In reply please quote: 19/08809

05 November 2019

**SSD-9601 – 780 WALLGROVE ROAD, HORSLEY PARK – PROPOSED
UPGRADES TO PLANT 2 – FAIRFIELD CITY COUNCIL SUBMISSION**

Overall Roof Plan

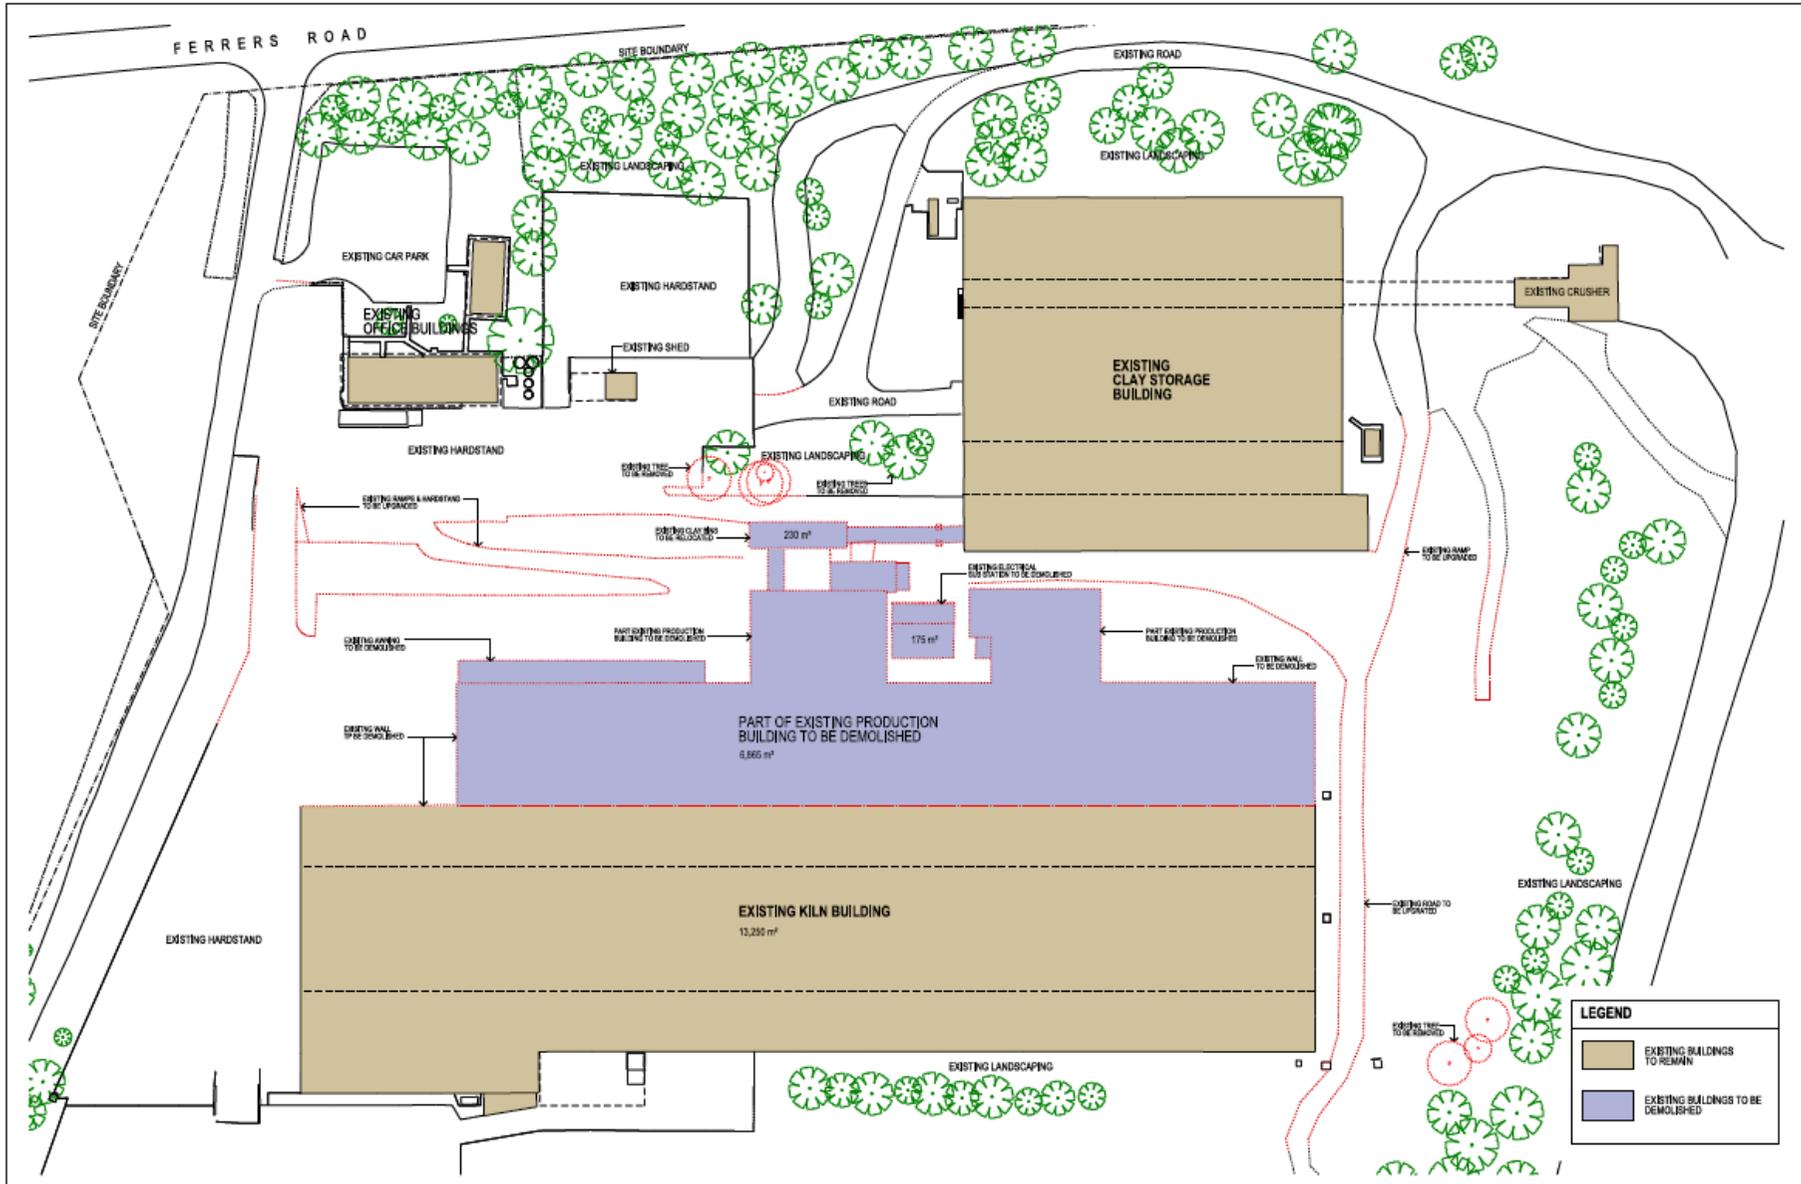
Council notes that a large area of office space is proposed to accommodate the existing 35-onsite staff. The 18 car spaces proposed is not considered sufficient in accommodating existing office staff, production staff and maintenance staff and in this regard the proponent shall provide sufficient parking to accommodate the development.
